Office of
Environment
& Heritage

St Leonards Private Hospital – Tower B (Detailed Design and Construction - 12 Frederick Street, St Leonards (SSD-8894) – Environmental Impact Statement

DESCRIPTION
ROOF LEVEL PLAN

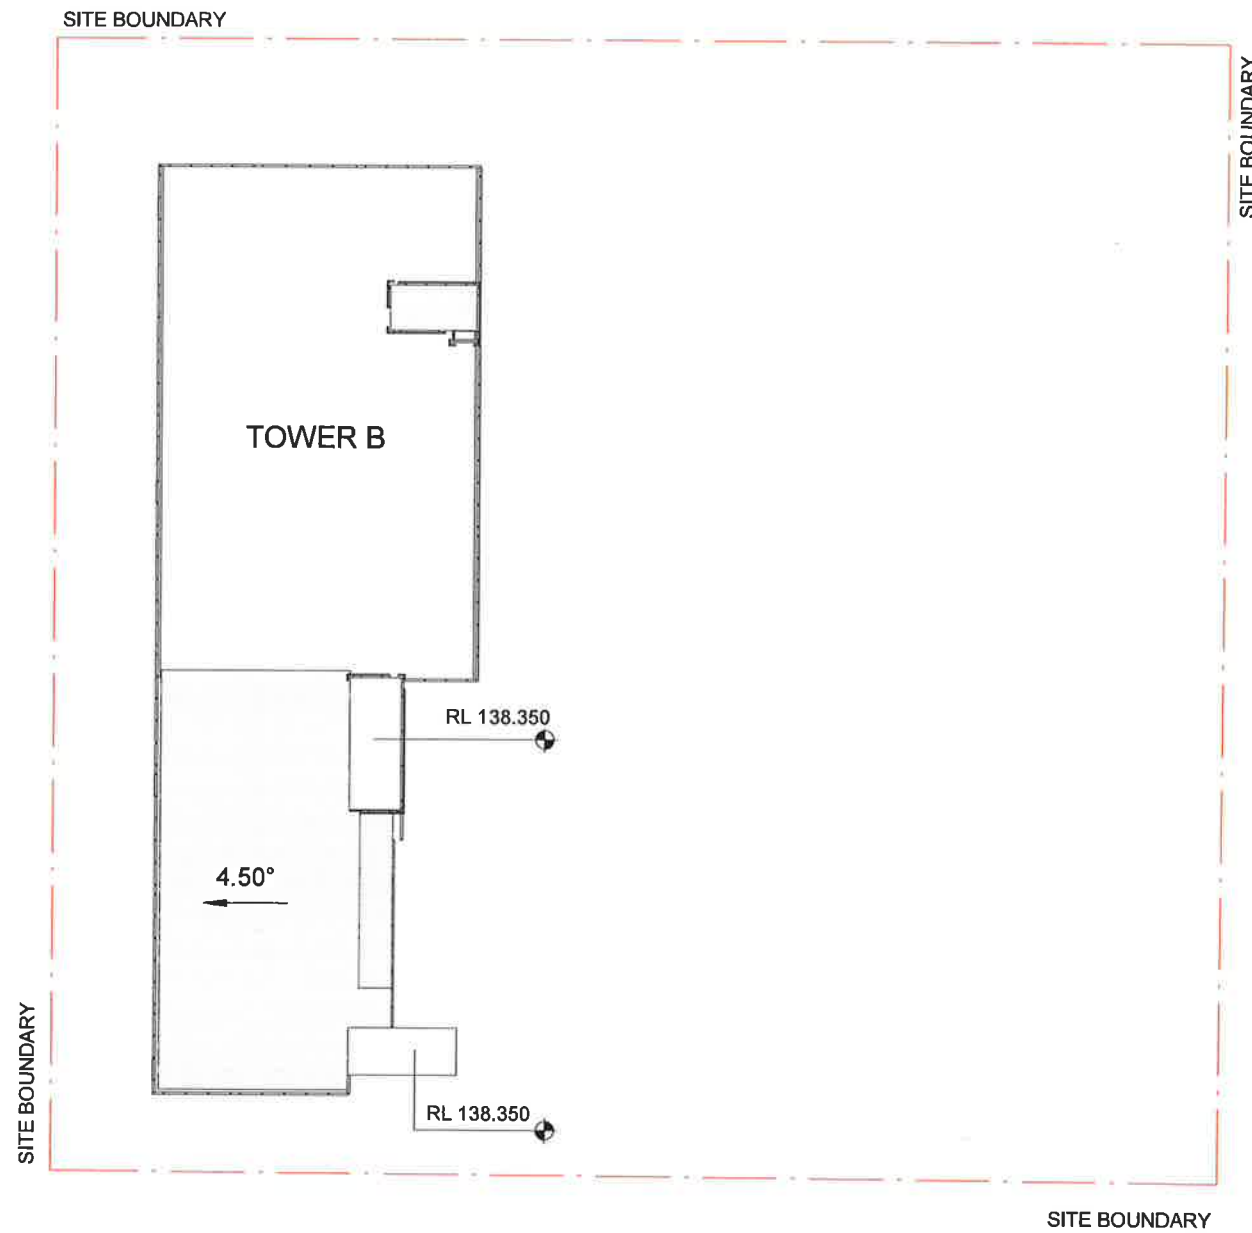
OEH recommends that if possible Tower B incorporates a Green Roof or Cool Roof into the design of the building. The benefits of Green Roofs and Cool Roofs are outlined in the OEH (2015) Urban Green Cover in NSW Technical Guidelines which can be found at the following link:
<http://climatechange.environment.nsw.gov.au//Adapting-to-climate-change/Green-Cover>

Green roofs are roof surfaces that are partially or fully vegetated. Cool roofs use reflective material to reflect and emit more solar energy than dark coloured roofs. Green roofs and cool roofs can have a strong regulating effect on the temperature of roofs and building interiors, reducing the energy needed for cooling and the impact of the Urban Heat Island effect. The provision of an Intensive Green roof would increase habitat and biodiversity at the site, particularly if local native plant species are used from the relevant native vegetation community.
